A19 Downhill Lane Junction Improvement

Scheme Number: TR010024

7.5(1) Revised plans, drawings and sections for the A19/A184 Testo's Junction Alteration Scheme

REVISED PLANS, DRAWINGS AND SECTIONS FOR THE A19/A184 TESTO'S JUNCTION ALTERATION SCHEME

Drawing status: **DCO PLANS**

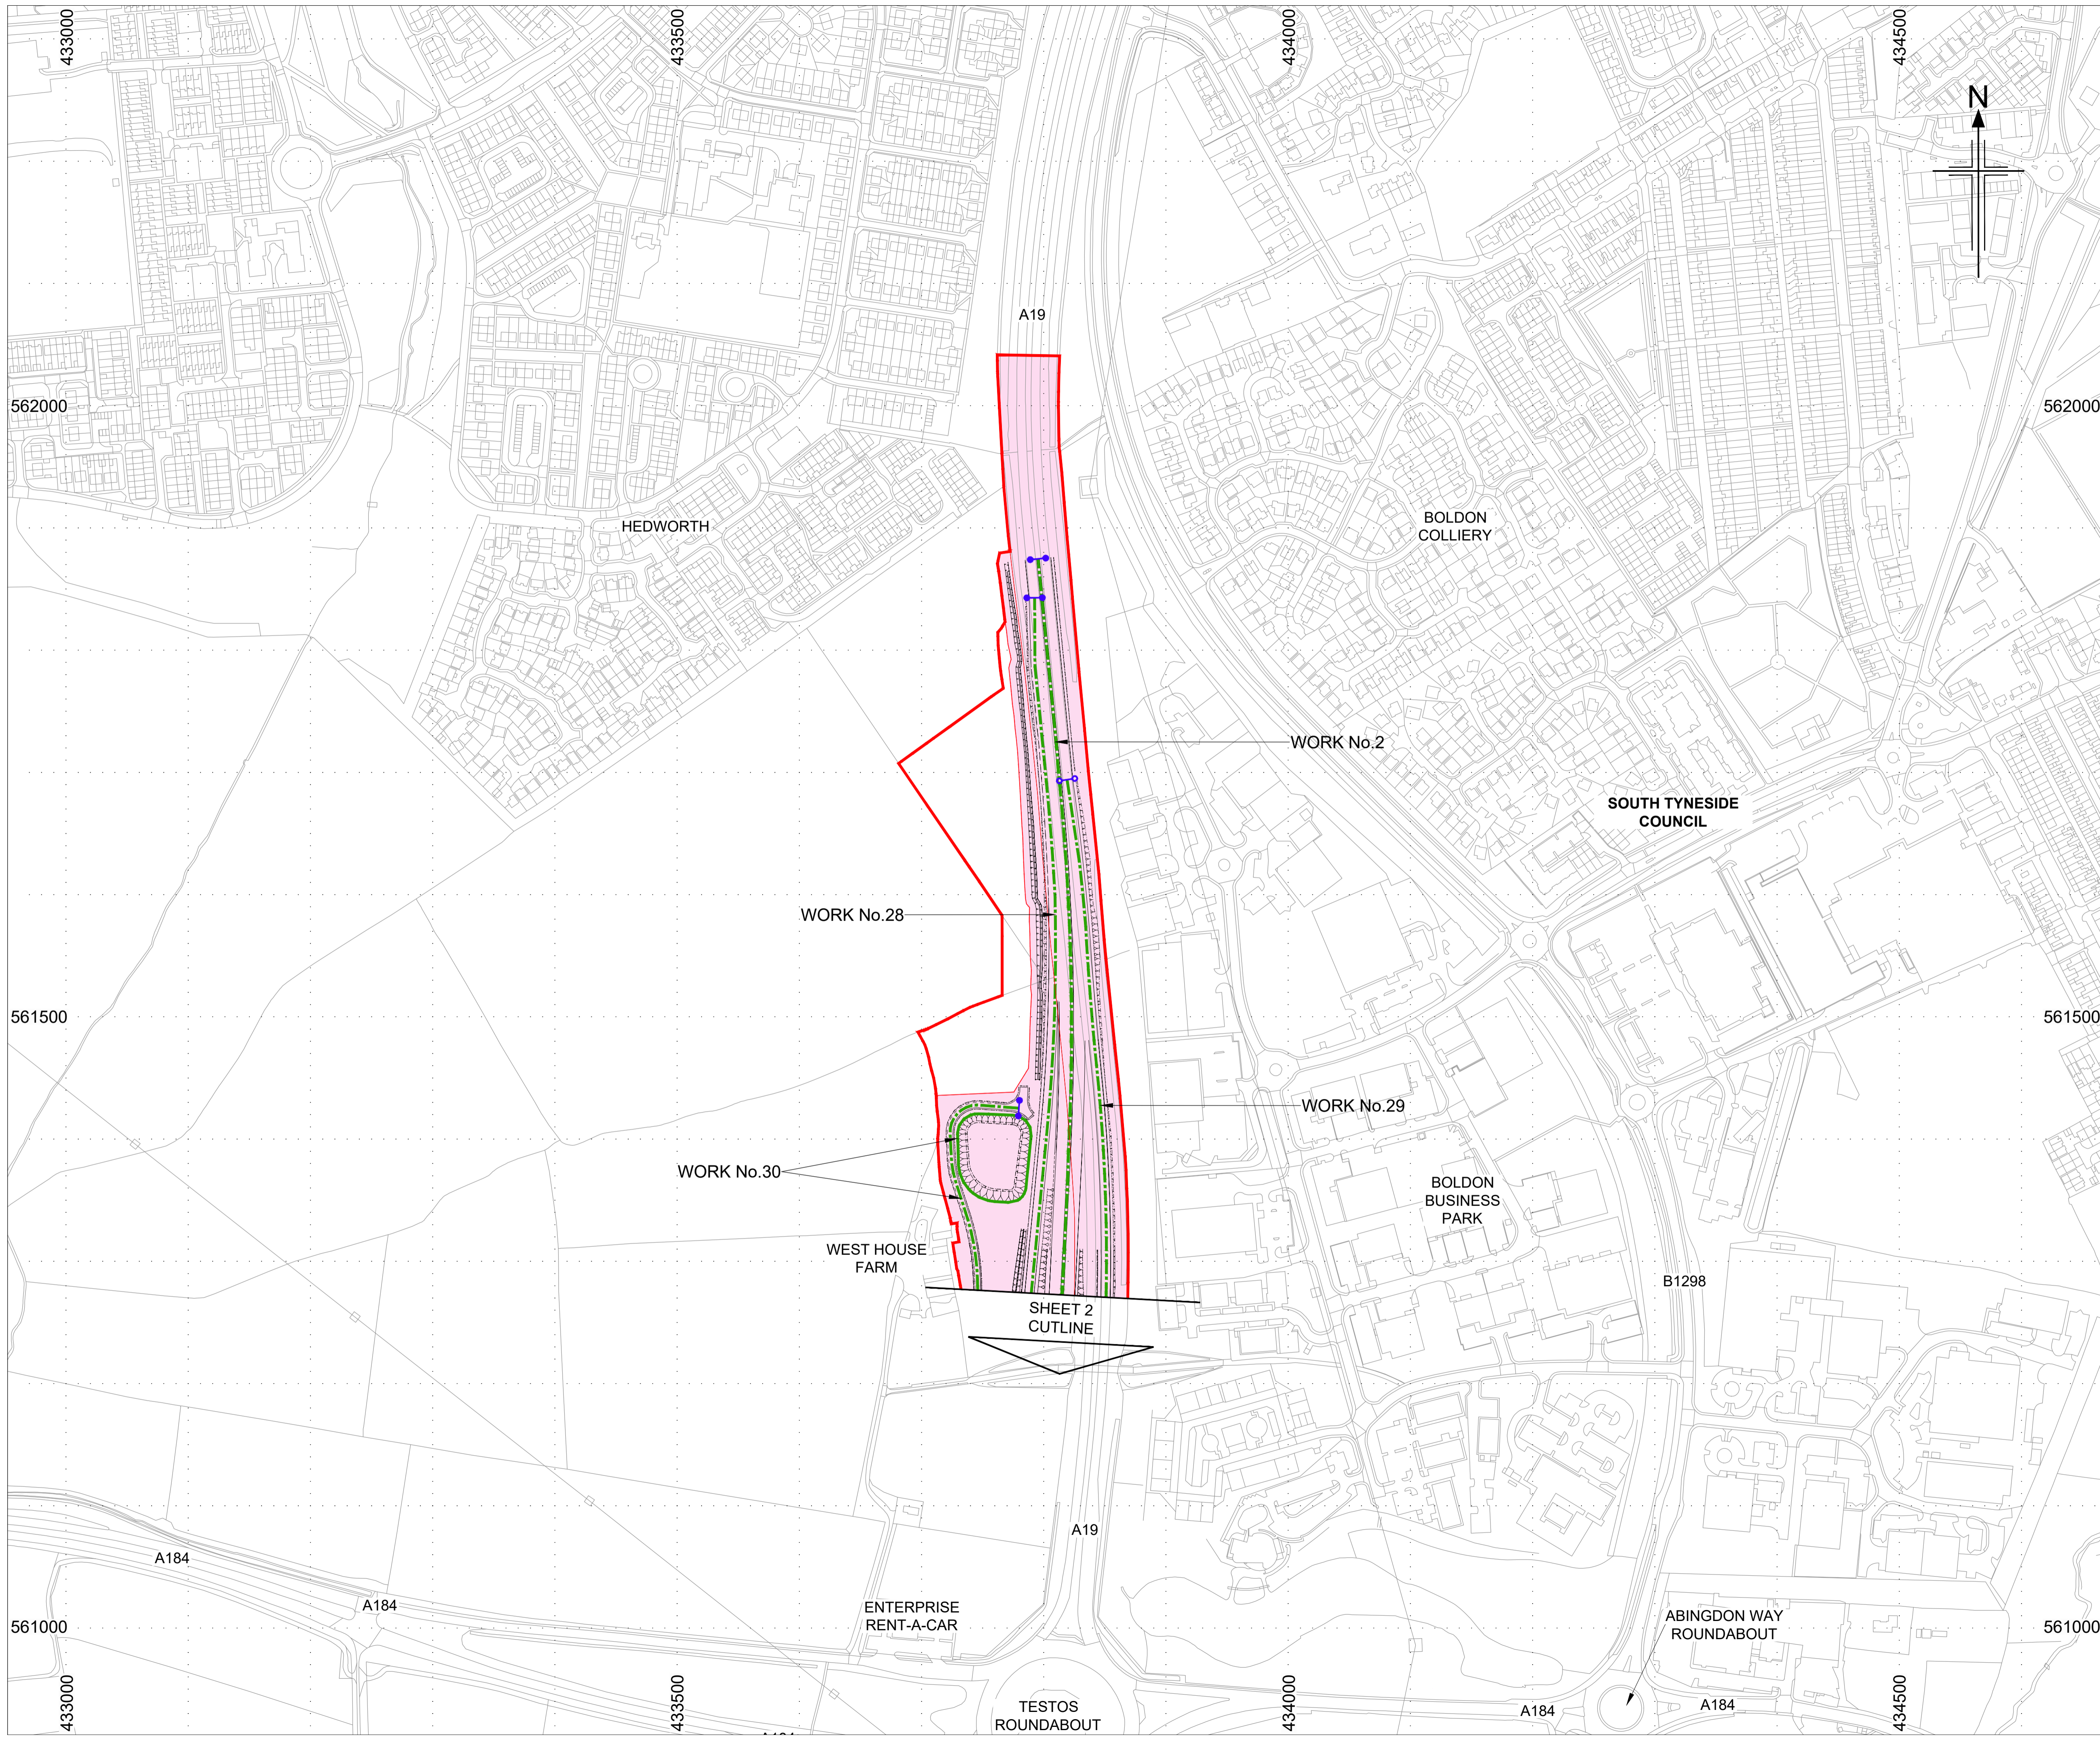
1.6.1 The revised Works Plans for the Testo's scheme have removed Works No. 4 ~~and 6~~ which ~~are~~ is the ~~associated~~ works in relation to the non-motorised route being removed ~~and the stopping up of B46 which is no longer required~~.

1.7 As the certified documents for the Testo's scheme relate to versions of volumes of documents (rather than individual sheets within them), updated sets of the entire Works Plans and Streets, Public Rights of Way and Access Plans have been provided. There are no changes to these plans aside from those listed in 1.6.1 and 1.6.2 above and therefore changes have only been made to Sheet 2 of both the Works Plans and the Streets, Public Rights of Way and Access plans.

Drawing title: **STREETS, RIGHTS OF WAY AND ACCESS PLANS REGULATION 5(2)(k) SHEET 2 OF 3**

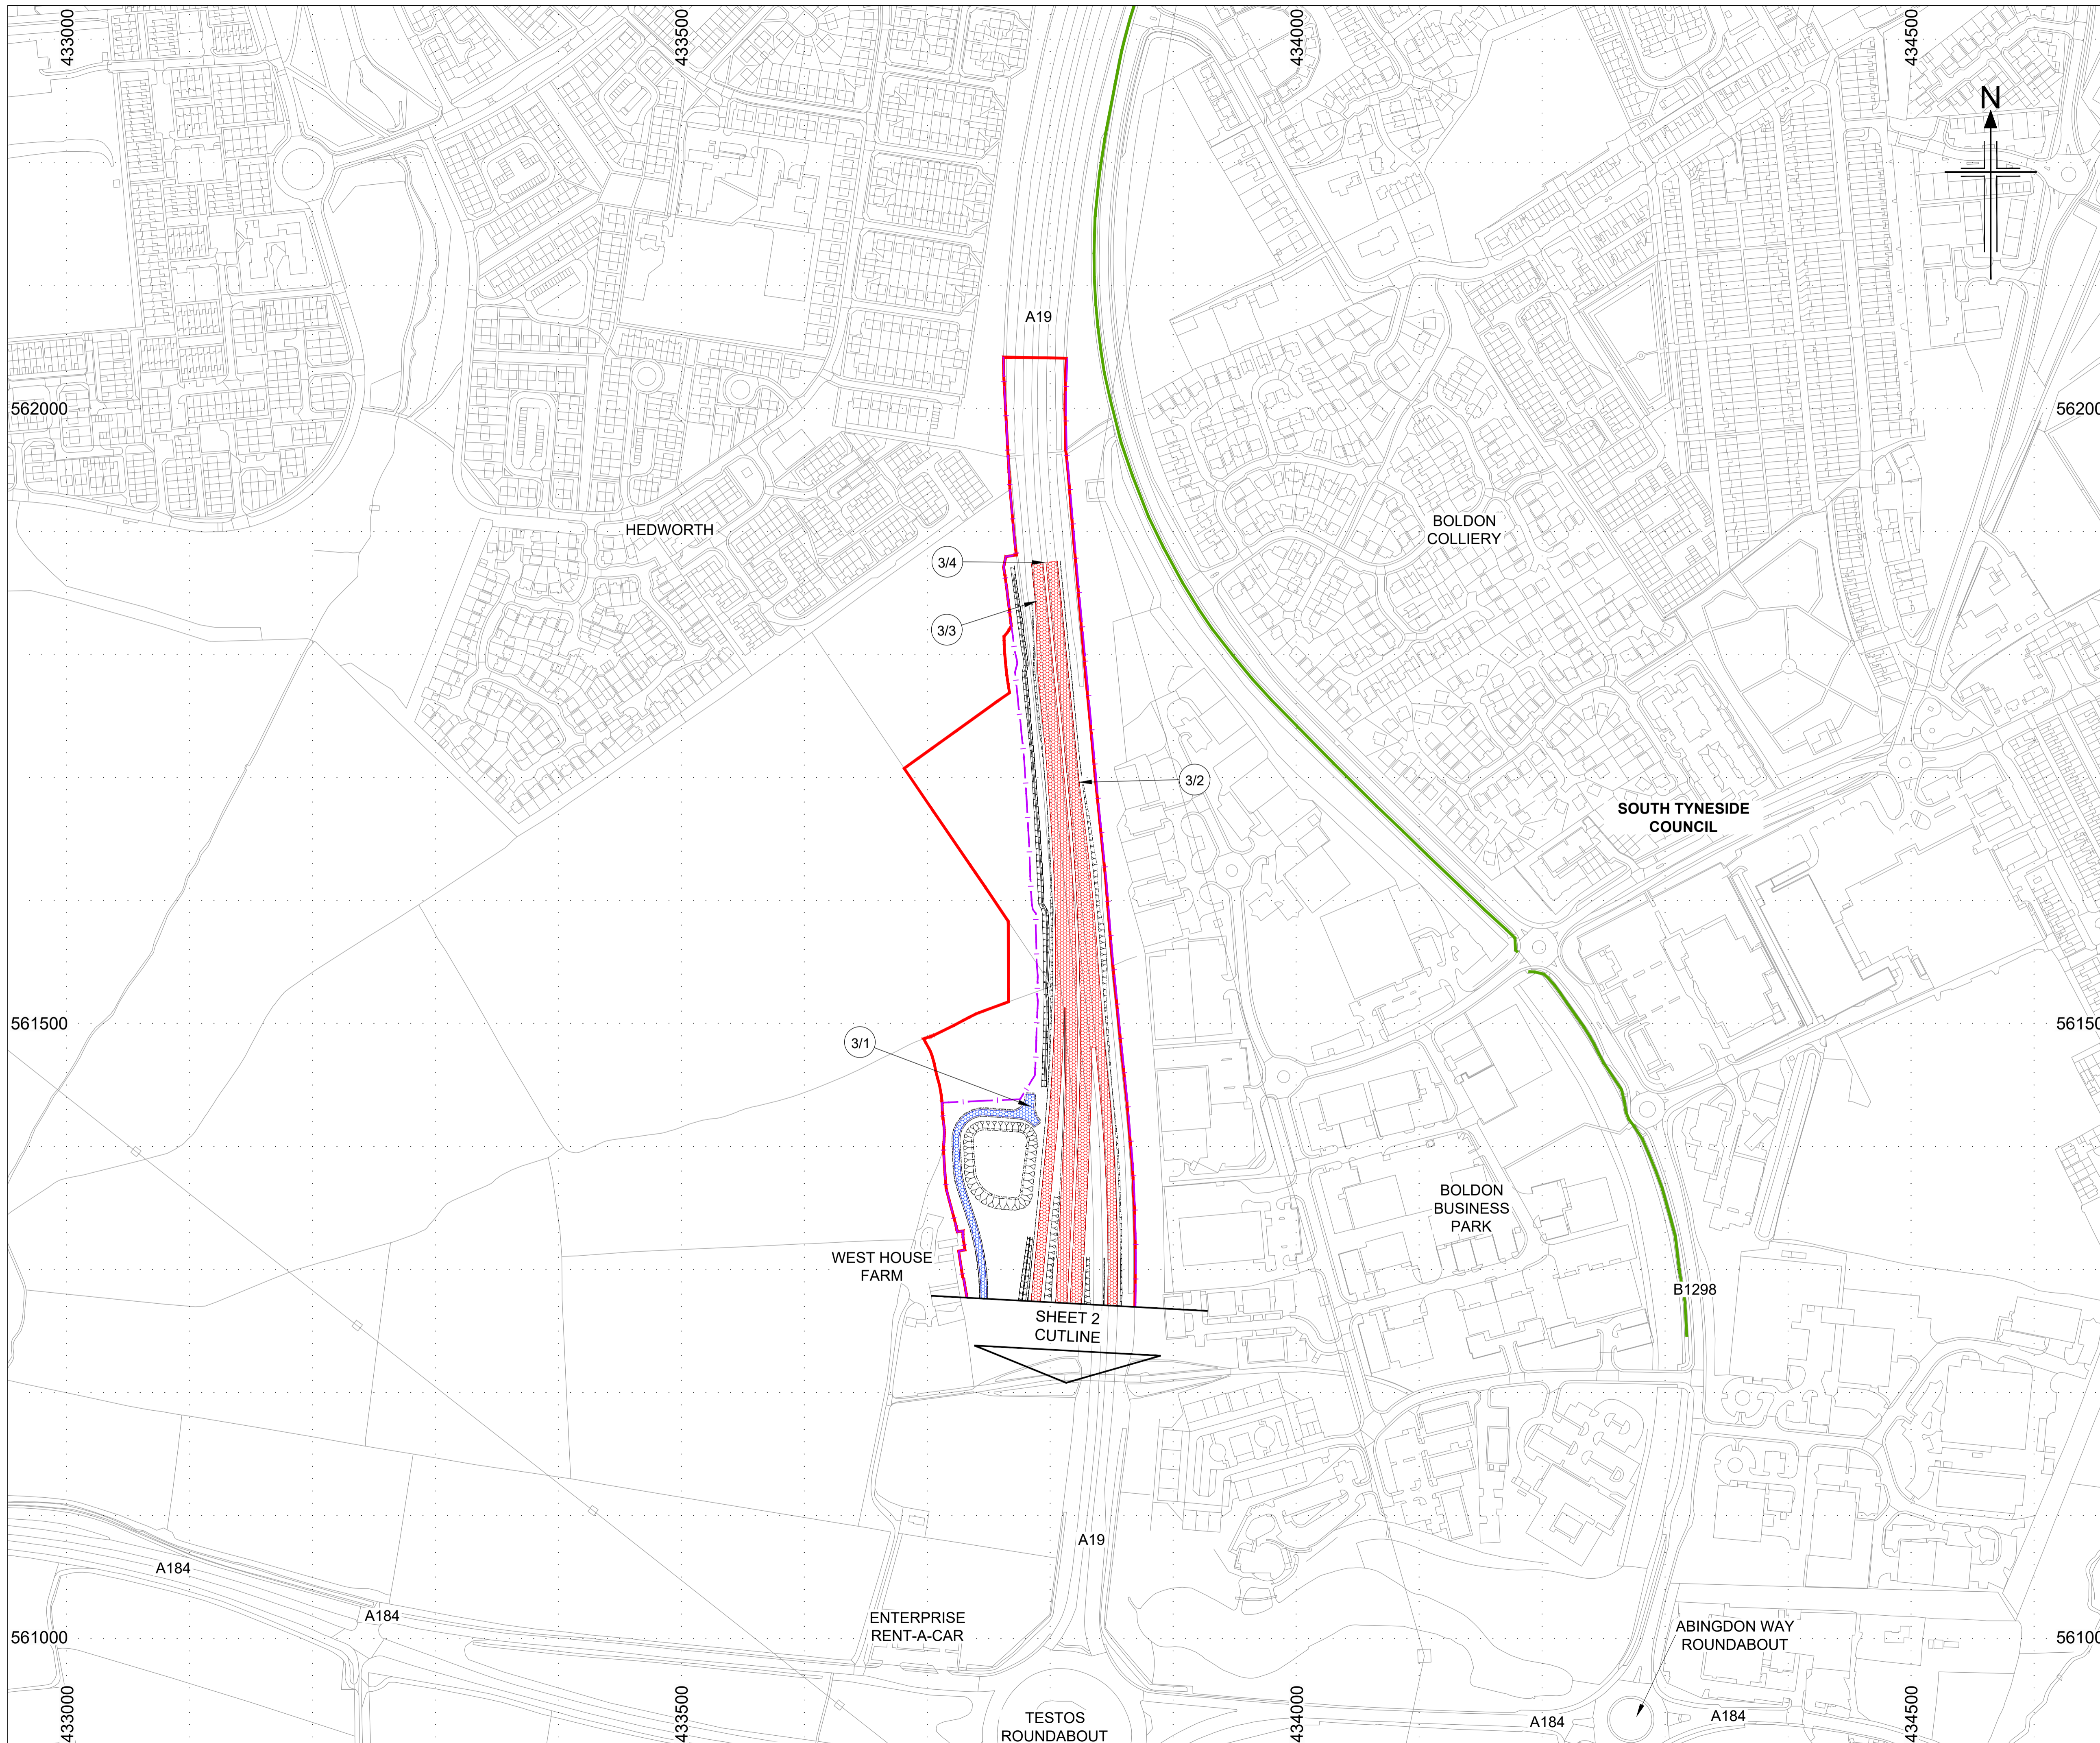
1.6.2 The ~~removed~~ Streets, Public Right of Way and Access Plans have omitted the references to the provision of the non-motorised route being removed (Work No. 4) and included the provision for the extinguishment of the further part of the B46 and the stopping up of the B46.
